Engineers Comments Regarding Conditions 5 and 6

Application No: Y/183/21/DOC

Site Address: Pollards Nursery Lake Lane Barnham PO22 0AD

Description of Works: Approval of details reserved by condition imposed under ref Y/151/20/PL relating to Condition Nos 5 - surface water drainage and 6 - discharge flows to watercourses.

**COVER LEVEL: 10.84
INVERT LEVEL: 9.90**

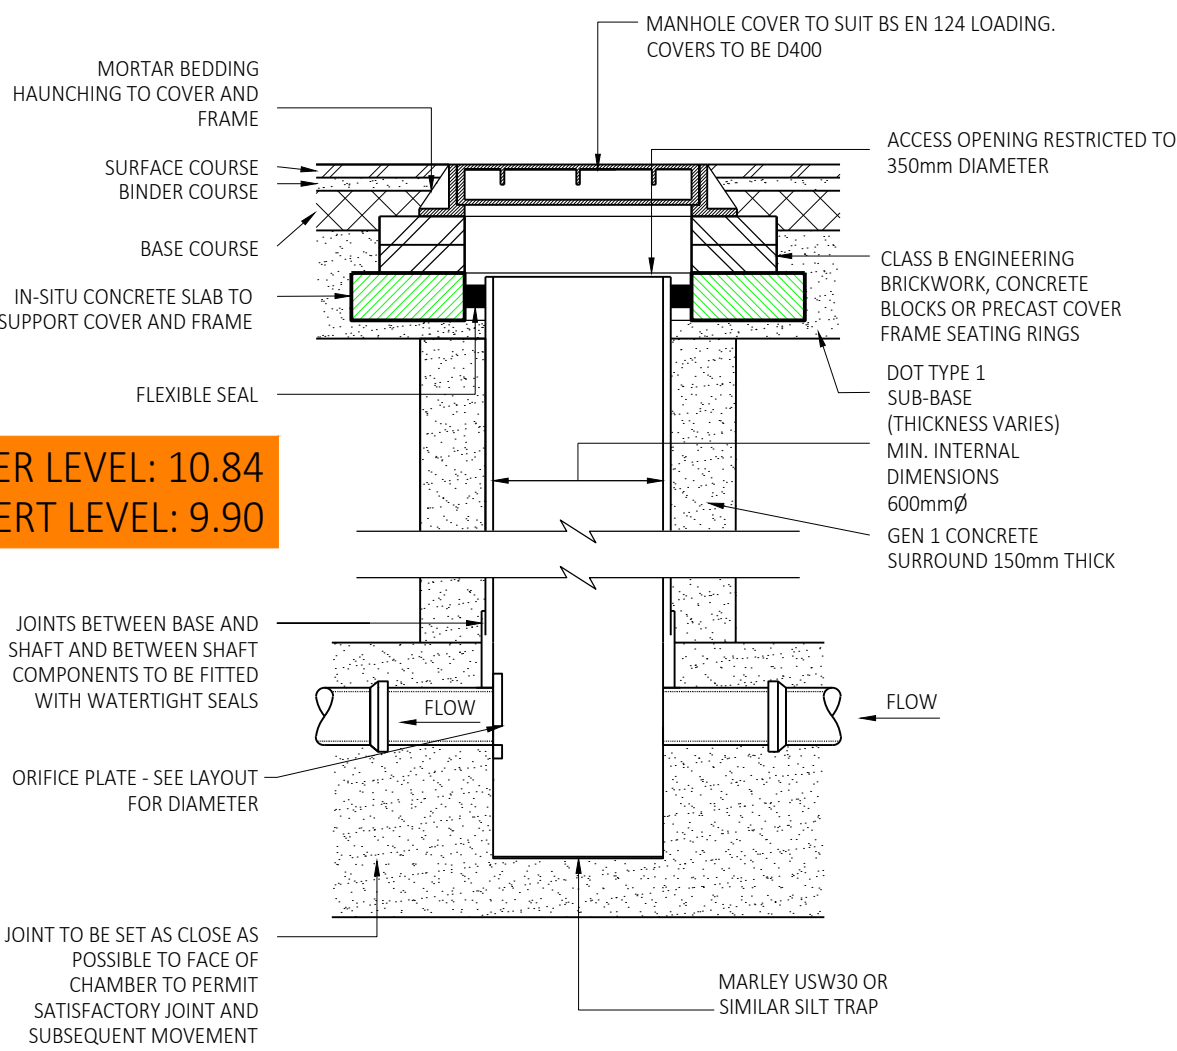
We recommend discharge of conditions 5 and 6. Please ensure the following are listed in any approval:

6215-DR11 Rev B Foul and Storm Drainage

Please note that should the land drainage consent process require changes to either of these drawings that a new discharge of conditions application will be required.

Drawing No: 6215 - DR10 Revision: D

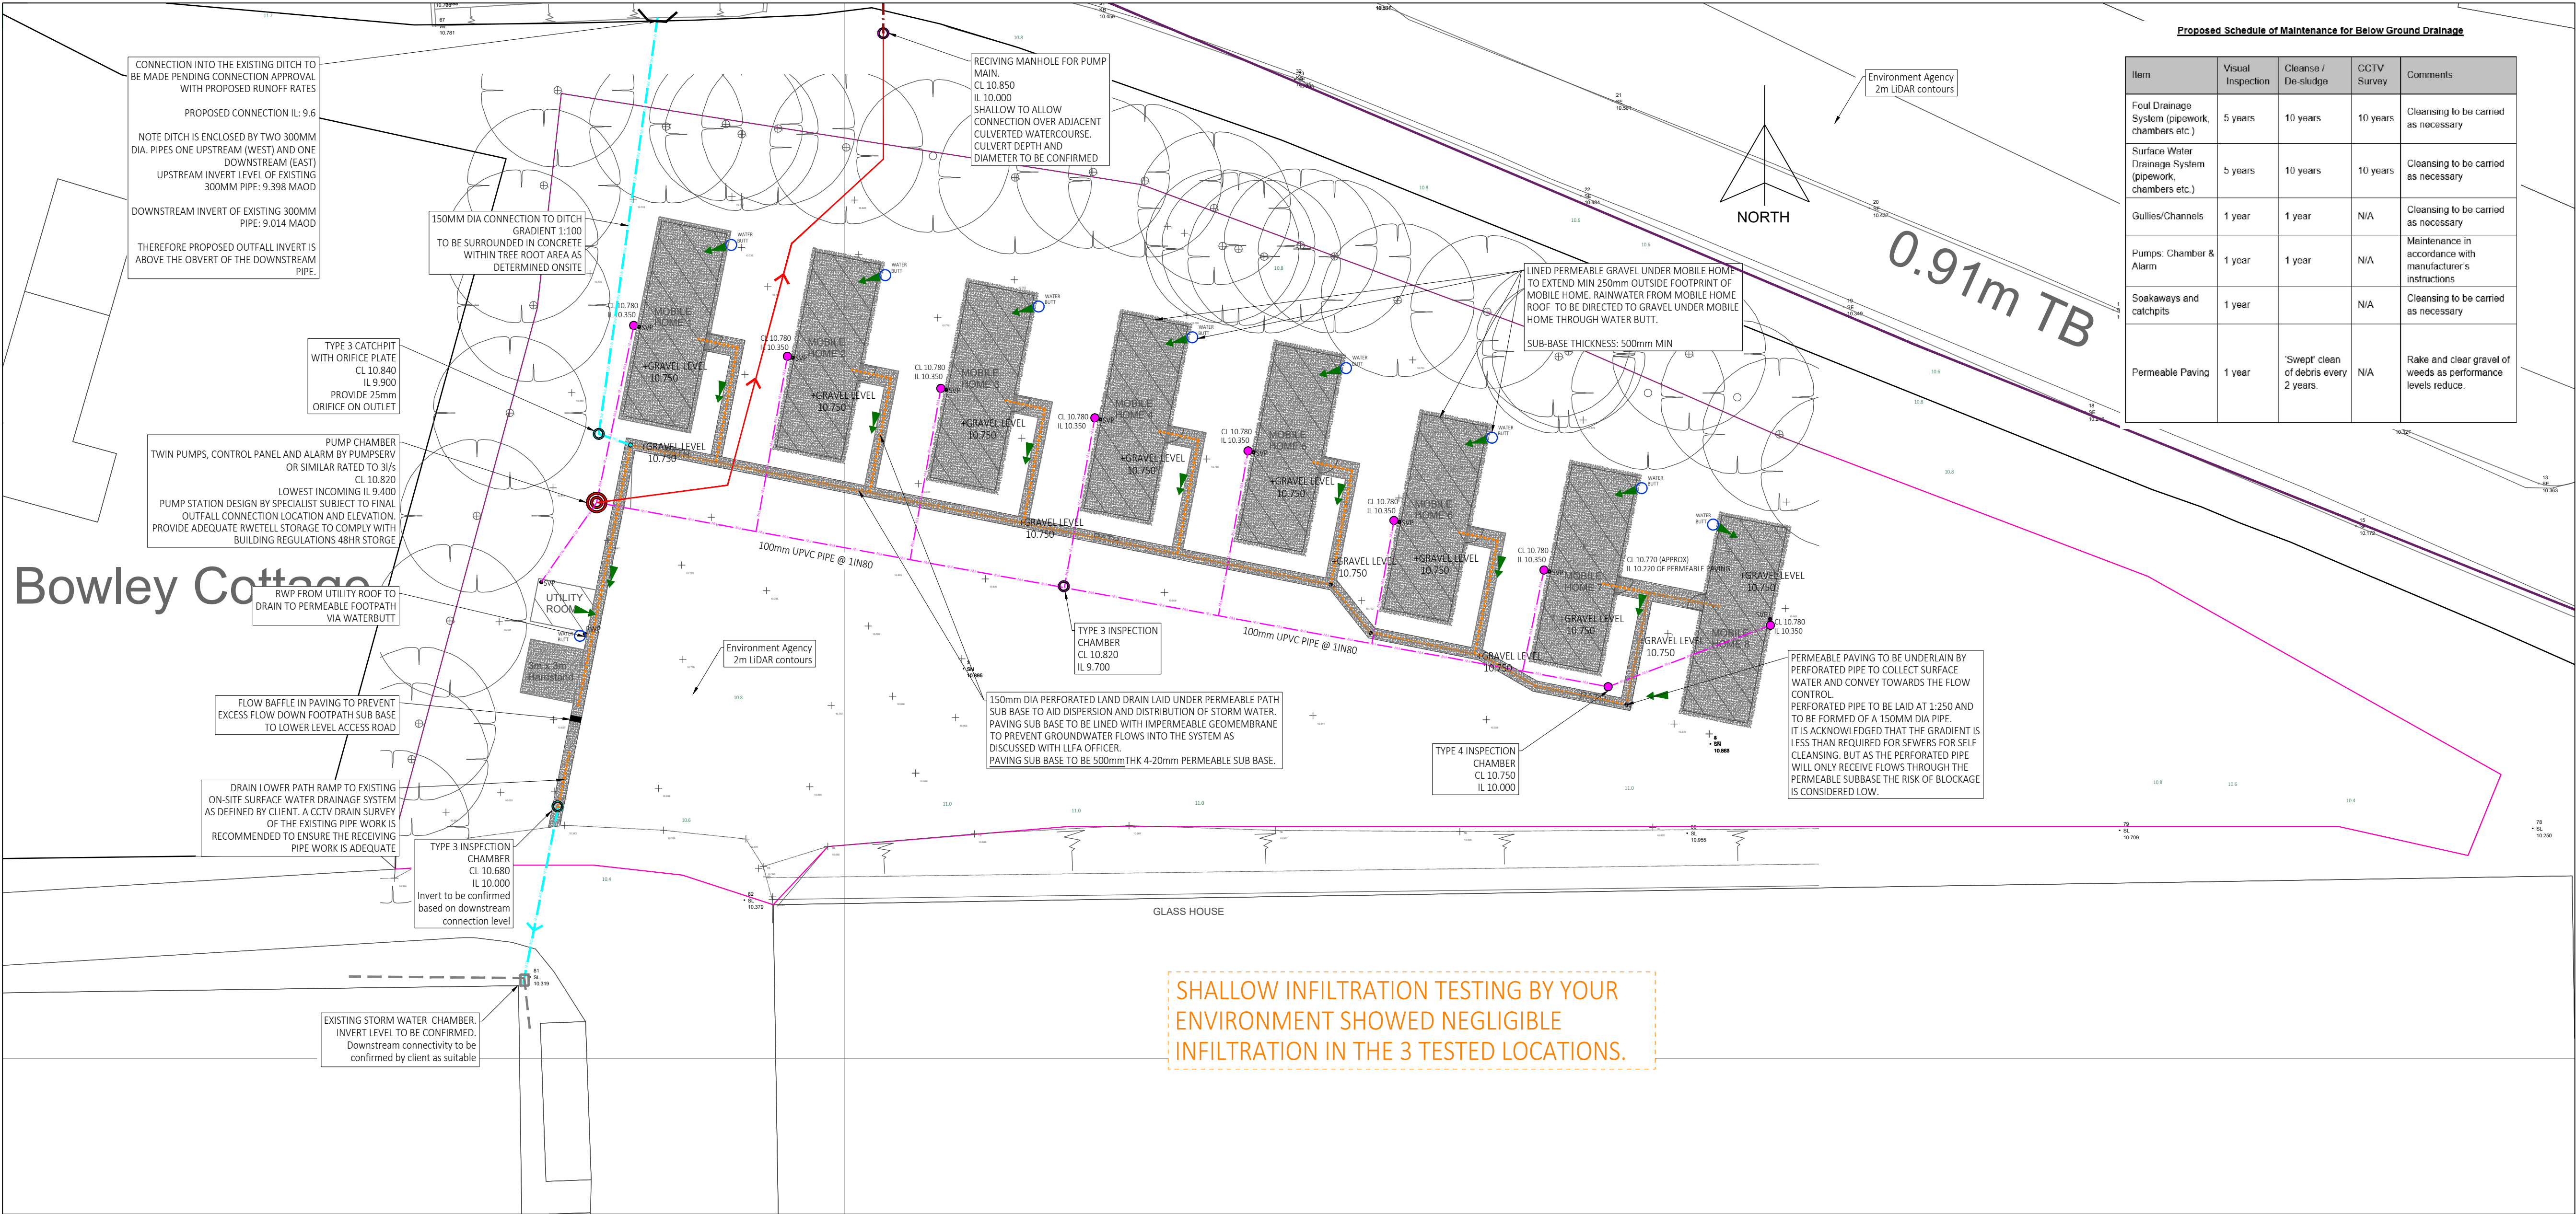
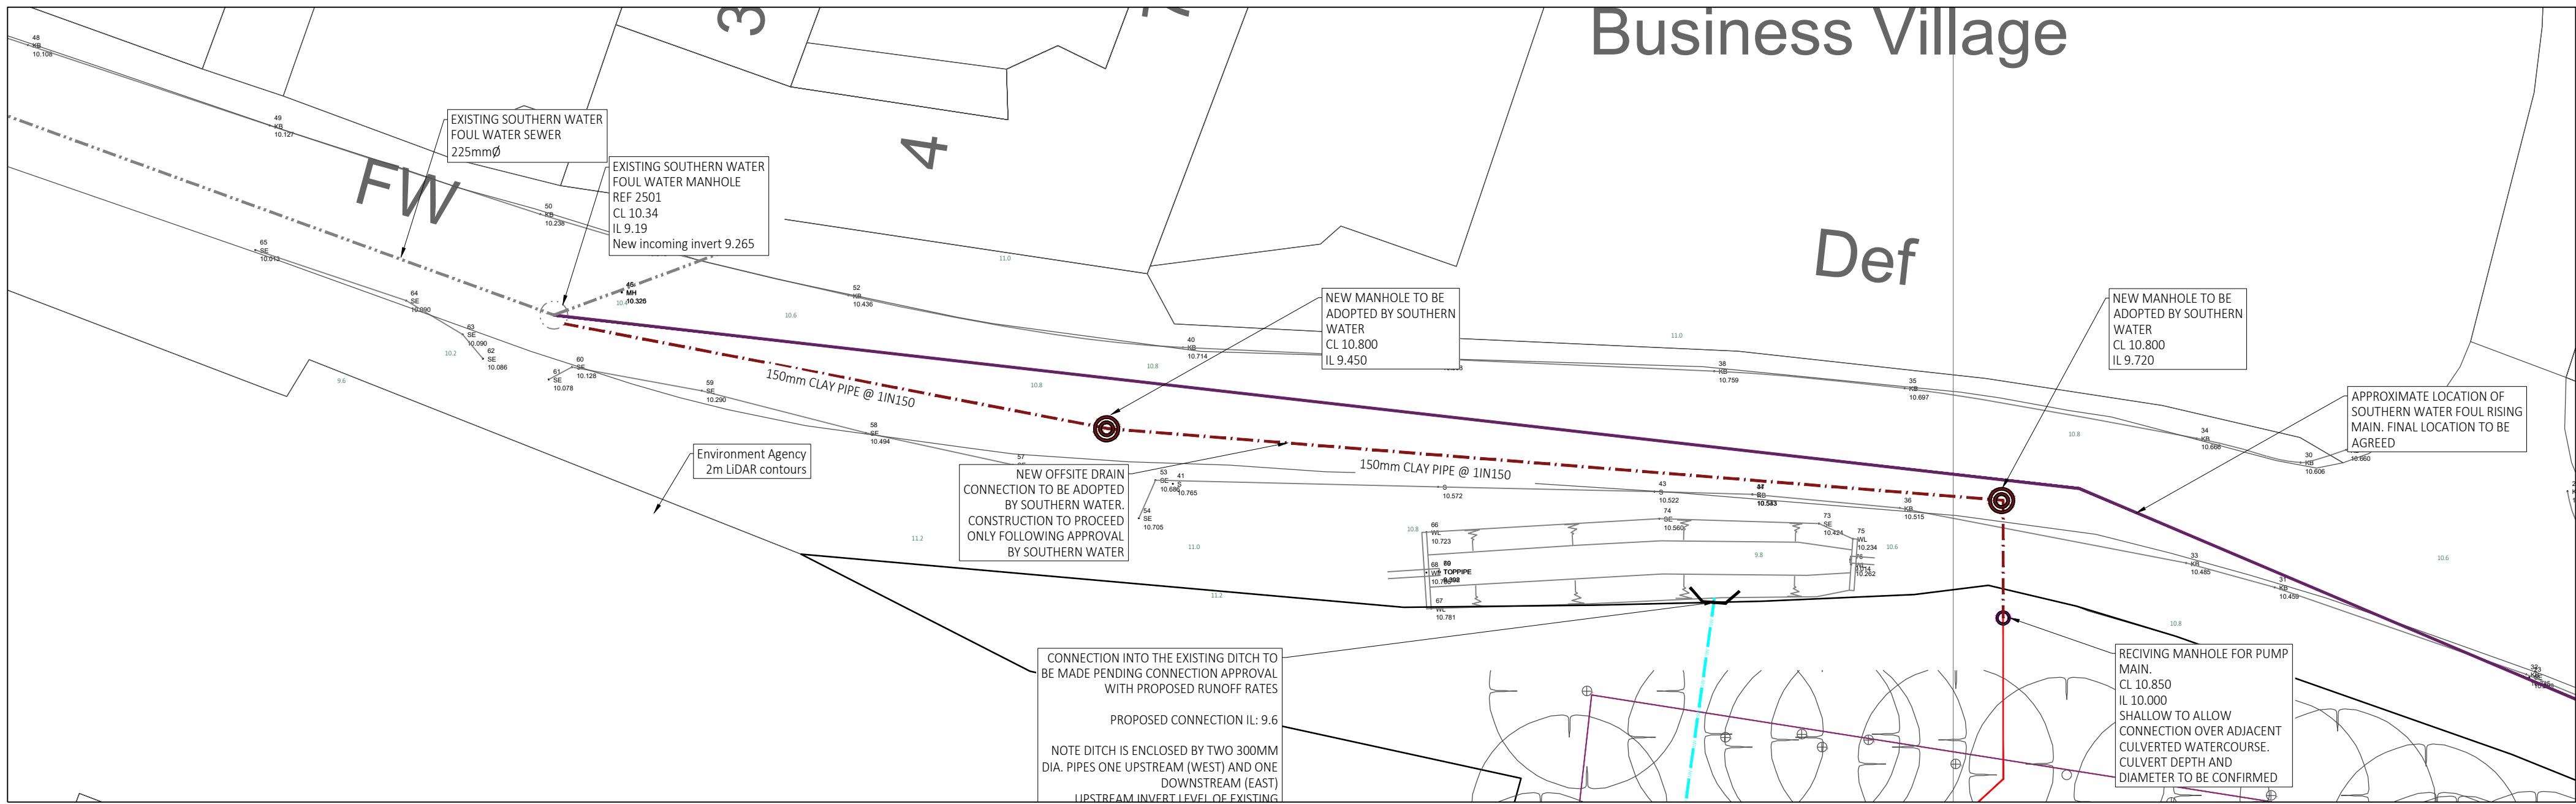
6215-DR10 Rev D Foul and Storm Drainage
